Address: 41 Moat Hill Farm Drive Batley WF17 0HR

Application number: 2020/94203	
What is the application for?:	Outline application for demolition of dwelling and associated outbuildings and t
Address of the site or building:	Clough House, 236, Leeds Road, Birstall, Batley, WF17 0HW
Postcode:	YO26 8EW

Type of comment: An objection

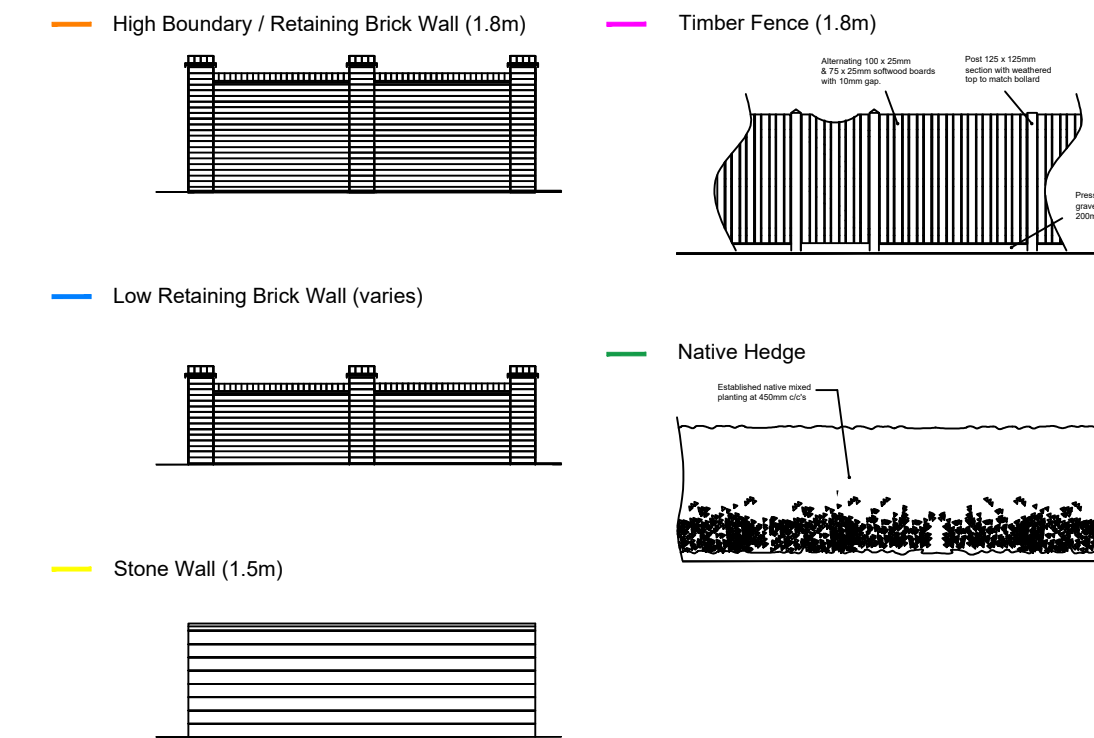
I see that there are two proposed self contained developments on the plan with entrances at the existing Clough House entrance on Leeds Road and also from Moat Hill Farm Drive. 23 properties will be accessed through Moat Hill Farm Drive and 7 from Leeds Road.

I strongly oppose that the majority of properties at the proposed development on Clough House should be accessed via Moat Hill Farm Drive and see no valid reason for this to be the case.

I am asking if a compromise could be struck whereby most of the access to the properties could be via Leeds Road i.e. access to 23 properties from Leeds Road and 7 properties via Moat Hill Farm Drive?
